PRE-HEARING STAFF ANALYSIS

Rezoning Petition No. 2008-050

Request: R-5, single-family residential to UR-1(CD), urban residential, conditional

REZONING PLAN FOR PUBLIC HEARING - PETITION #2008 - 050

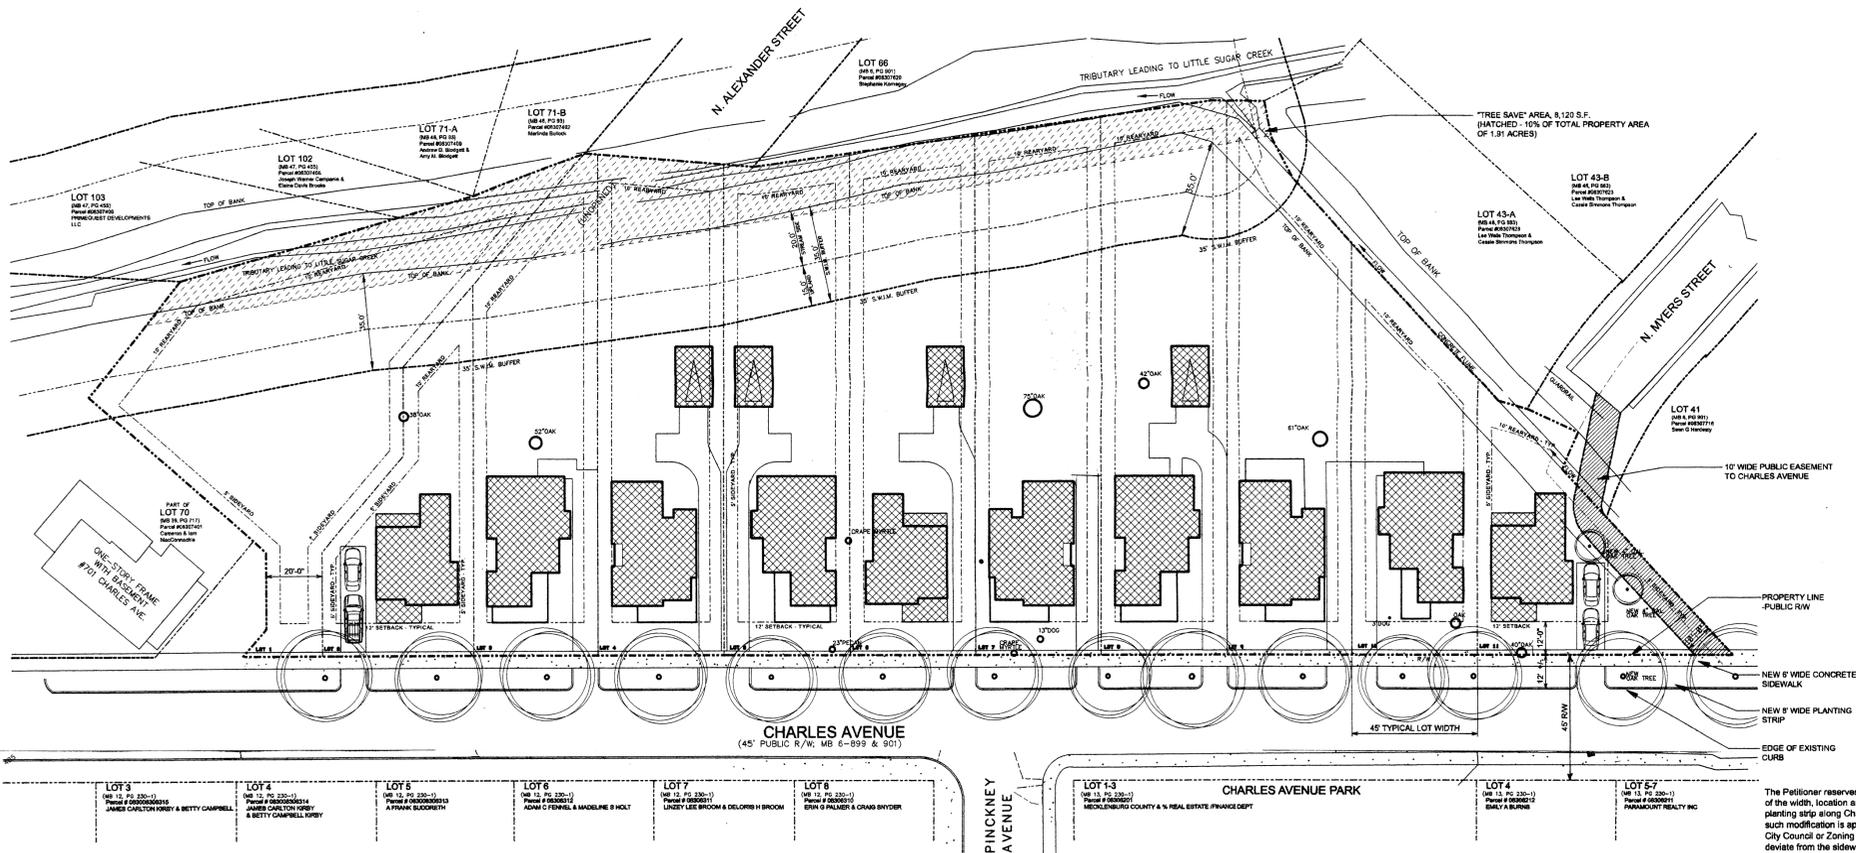
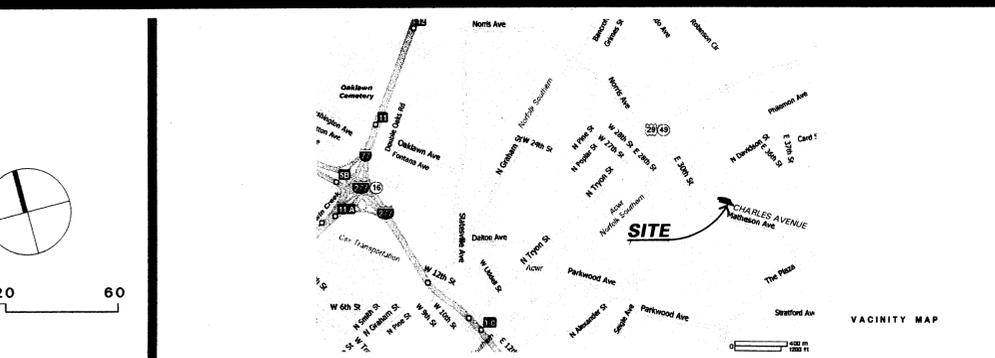
- The plan needs to show proposed building locations, driveways, and parking areas (garages, alleys, pads, etc.). There is insufficient information to determine how this site would be parked or if the commitment of providing two off-street parking spaces per unit can be met. Use of shared or paired driveways or a rear alley is strongly encouraged.

- To meet the requirements of the UR-1 District, the developer must remove the existing monolithic curb and sidewalk on Charles Avenue and construct an 8-foot planting strip and a 6-foot sidewalk.

- In conformance with the adopted Urban Street Design Guidelines, Charles Avenue needs to be designed as a Local Residential Street-Medium (27' back of-curb to back-of-curb, or 13.5' from the centerline of the street to the back-of-curb). The location of the new curblines is dependent on the parking that can be provided for each unit on-site (see comment 1). If sufficient parking cannot be provided on-site, then on-street parking will be necessary and require additional street width.

- CDOT can support the abandonment of the unopened or "paper" streets (Alexander and Myers Streets) conditioned on a 15-foot easement being provided between Myers Street and Charles Avenue for a pedestrian/bicycle connection. Depending on review/approval of a detailed cost estimate, CDOT may be able to assist in the funding of what CDOT estimates to be approximately half of its cost. At this time CDOT believes that this would include funding the bridge and the offsite work, if the developer funds the on-site work and does all of the construction. The connection would need to meet ADA requirements, be at least 10 feet in width, and be located within a 15-foot easement.

- There is a small triangular piece of acreage adjacent to the unopened N. Myers Street right-of-way. Petitioner needs to confirm ownership of this acreage.
- The proposed development/layout is contingent upon abandonment of rights-of-way. Confirm with CDOT abandonment is acceptable.
- Petitioner should revise site plan to indicate street setback is 14 feet from back of curb.
- Petitioner should indicate on site plan how proposed 10-foot wide public easement to Charles Avenue will be improved.
- Petitioner should show tree save area and indicate percentage on site plan (minimum 10%).
- The site plan shows Charles Avenue has a 45-foot right-of-way width. Confirm with CDOT if this width is adequate, or if dedication of right-of-way will be required.
- The storm water notes should be added to site plan.
